From: Claire Hughes [REDACTED]
Sent: 06 August 2019 19:46
To: Neil Crowther <Neil.Crowther@arun.gov.uk>
[REDACTED]
Subject: Planning application; WA/63/19/PL

We want to object to some aspects of the above planning application;

1. LOCATION OF PLOT 1

PLOT 1&2 - PLANS & ELEVATIONS

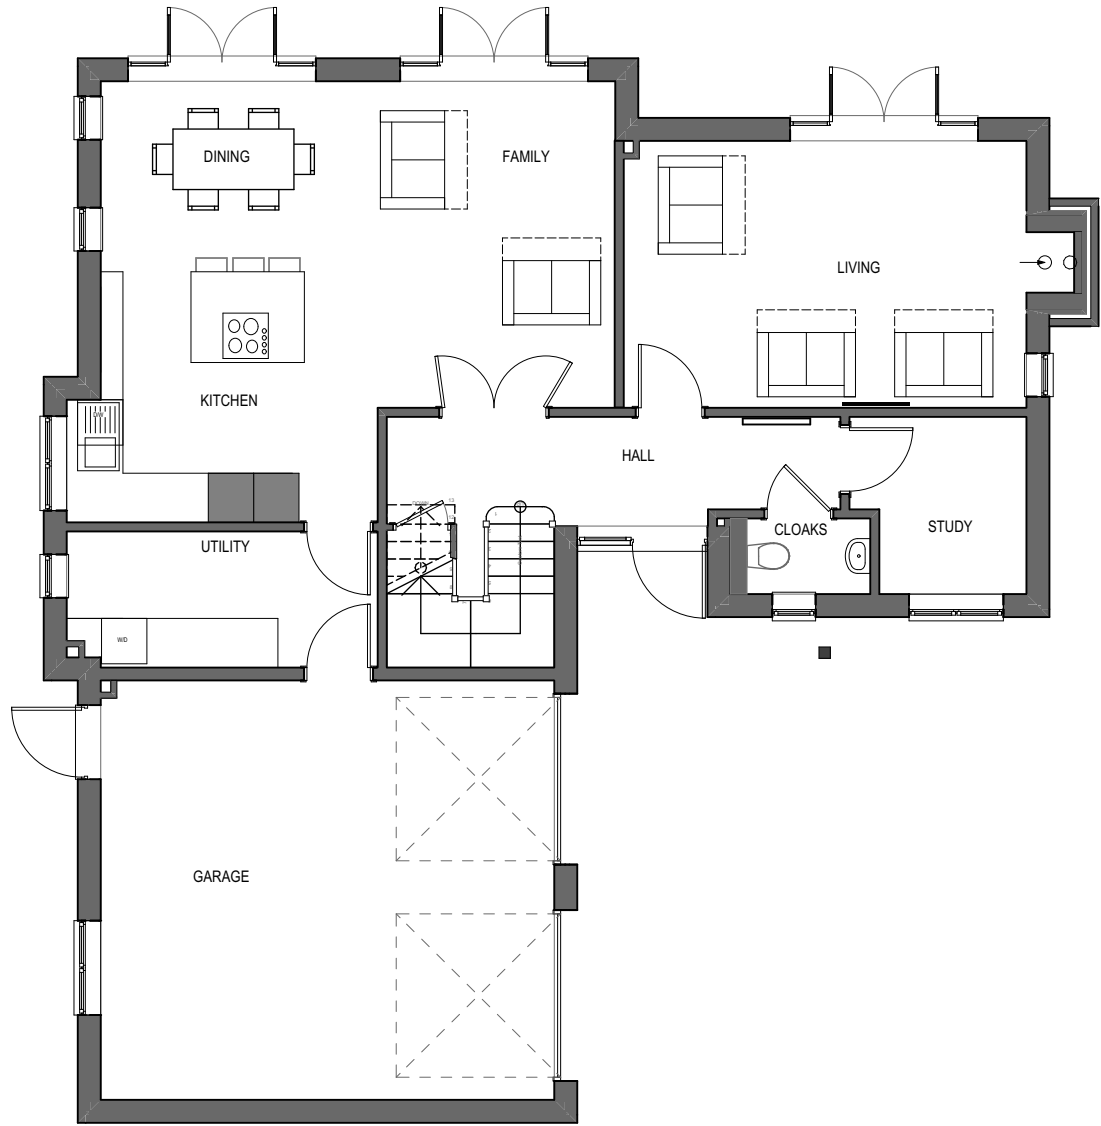
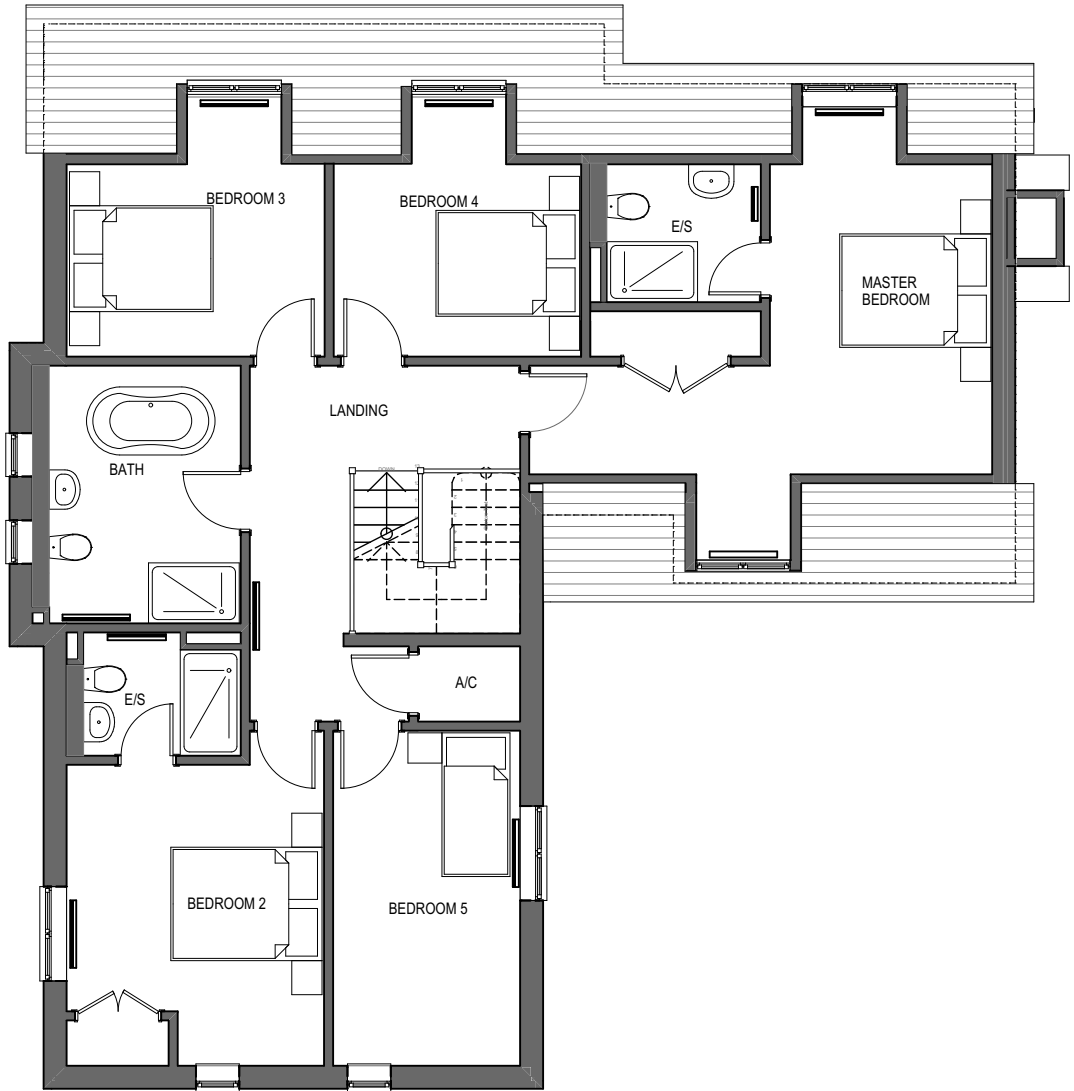
Firstly, and most importantly to us is the location of plot 1 as per Crayfern homes plan. You will see, from the plan, that Crayfern homes has submitted a plan for 8 homes. This is totally acceptable to us and we are happy with the

quantity. However, we are very unhappy about the position of plot 1 and wish the location of this house to be moved. We are very concerned that the proposed property is going to be EXTREMELY close to our boundary fence overlooking our garden and house, giving us no privacy that we currently have, and was the whole reason we moved here!

Crayfern homes wants plot 1 and 2 to remain where they are so they can be used as a selling feature , I quote " a gate-house function, symmetrically framing the entrance to the site and delivering a sense of "arrival"." So, as you can see this is just a selling feature for them but once the development is sold Crayfern will have no further interest in this plot, whereas we will be left with a house overlooking our garden and house that will affect us forever. This field has the size to accommodate plot 1 elsewhere (we have attached a quick plan we drew up ourselves showing how the properties can be moved around giving us the privacy we deserve.) The gatehouse style effect feature is a temporary selling point, people will buy these properties regardless of this feature, so we want plot 1 to be moved away from our property.

The location of plot 1 is 20-22 metres from our house bringing it very close to our boundary fence. In the plot there are trees all along our fencing providing great privacy, however, these will need to be removed if plot 1 remains as is proposed, giving us even less privacy. Even if Crayfern homes replant trees/shrubs for screening these will not provide the same screening as is currently there due to plot 1 being in the way! We would like these trees to remain untouched and wondered if TPO's can be put on them please.
